Certificate of Occupancy

LOCATION 27 Monument Sq CBL 027 F002003

RE: 27 (28) Monument SQ
CBL: 027 F002
Permit #07-1017/09-0416

List of code corrections to be addressed for certificate of occupancy:

CLIENT  
DATE  
DRAWN BY  
CHECKED BY  
DATE AUG. 08, 2008  
SHEET TITLE  
BASEMENT MECHANICAL PLAN

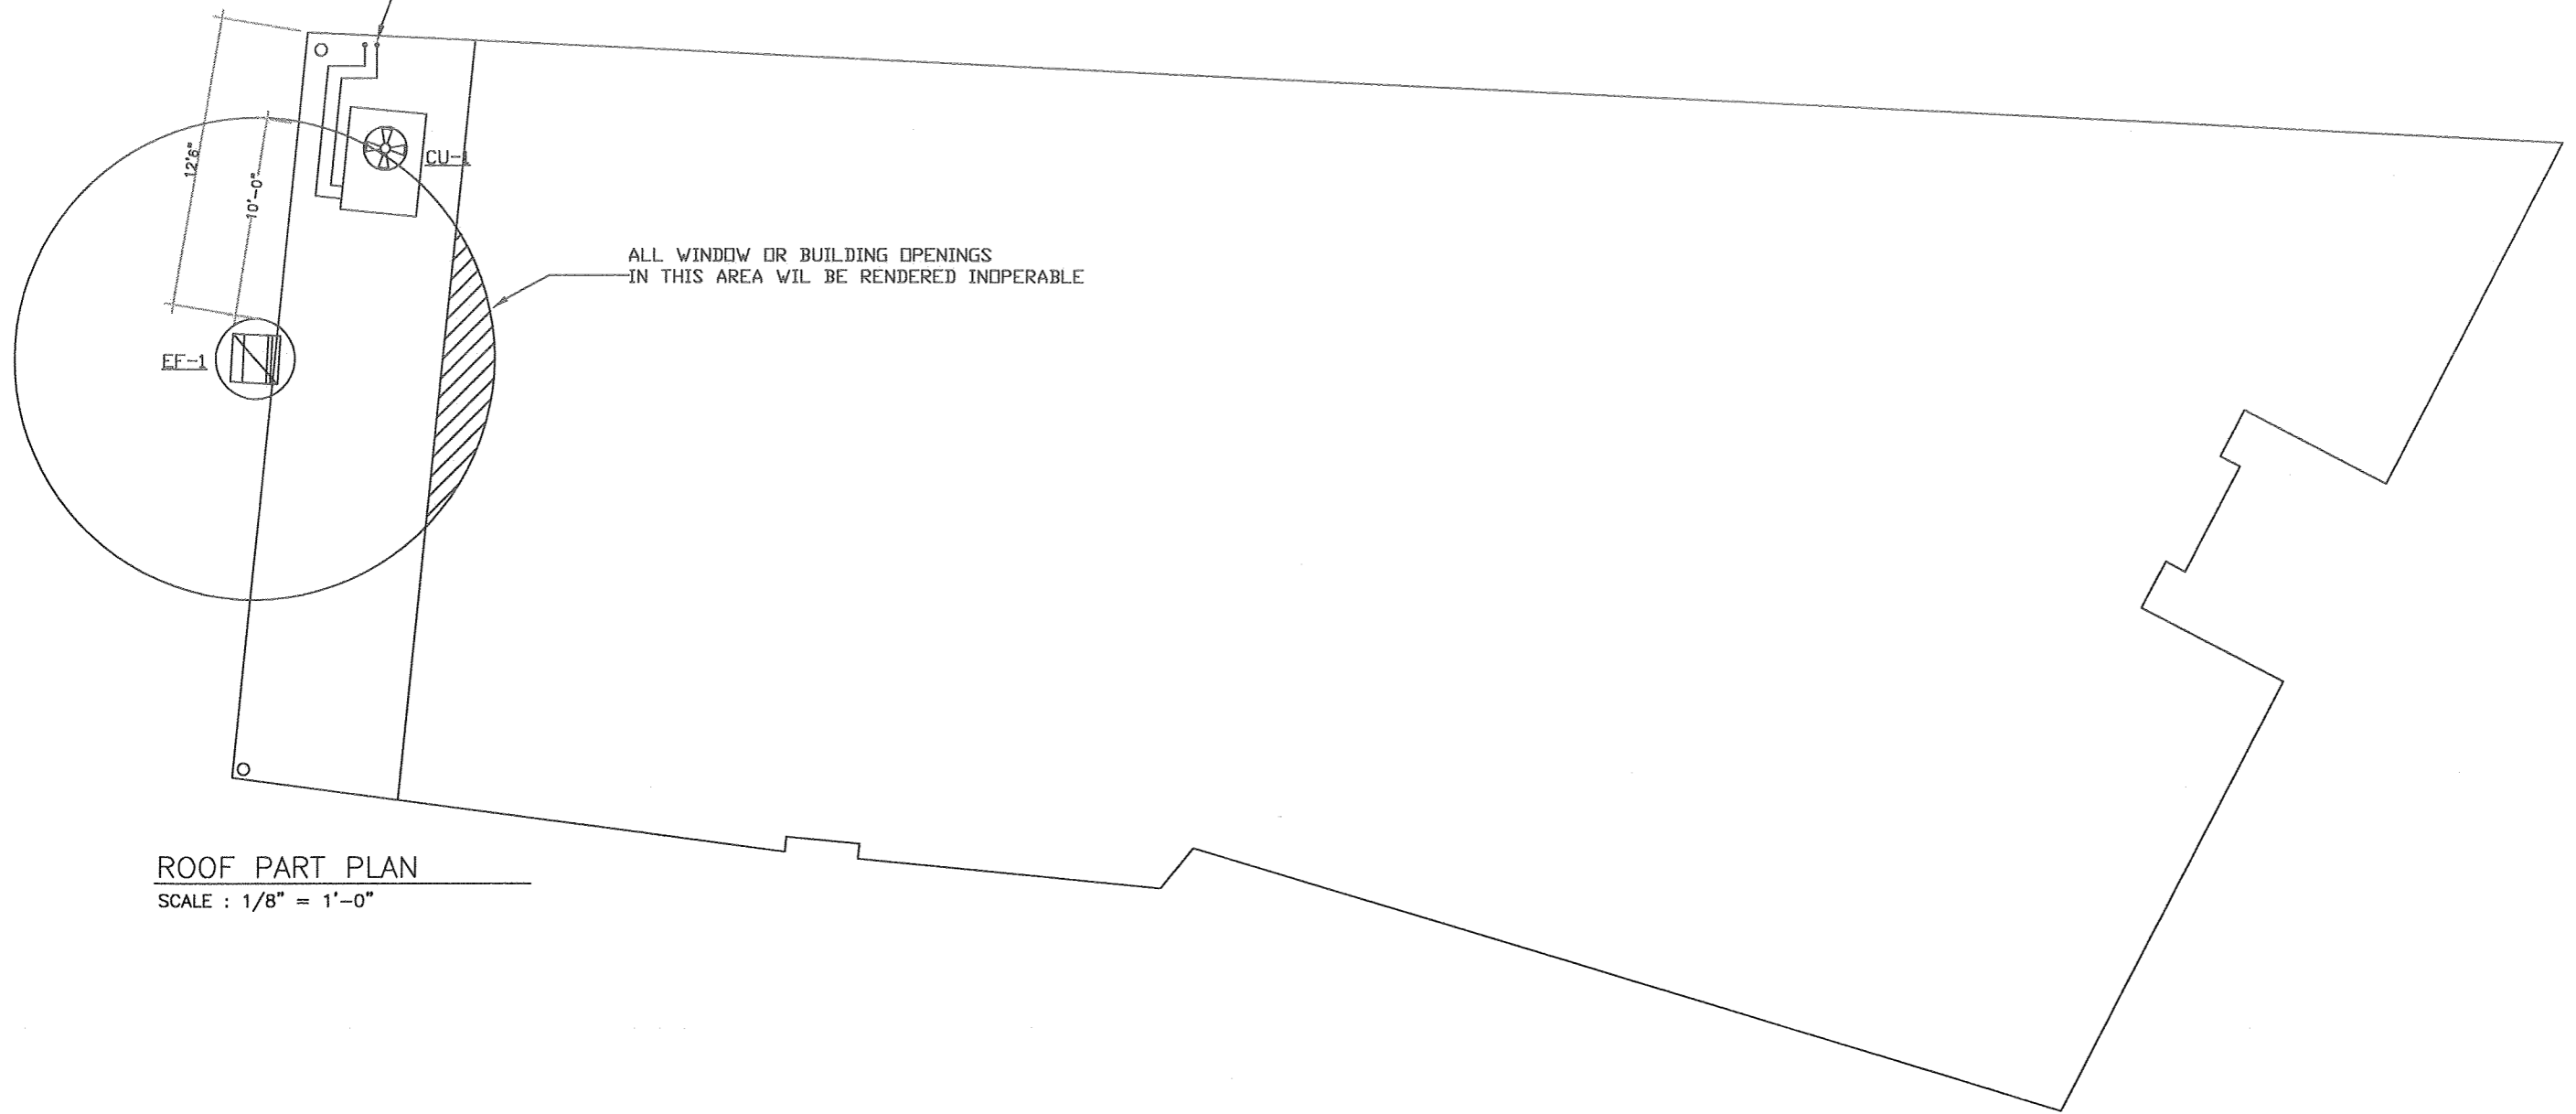
1. Sprinkler head in fire panel room
2. Seal/protect stair enclosure penetrations
3. Securing of electrical wiring/Fire Alarm cables in the basement
4. Address elevator sump hose penetration through rated shaft and connection to indirect plumbing drain
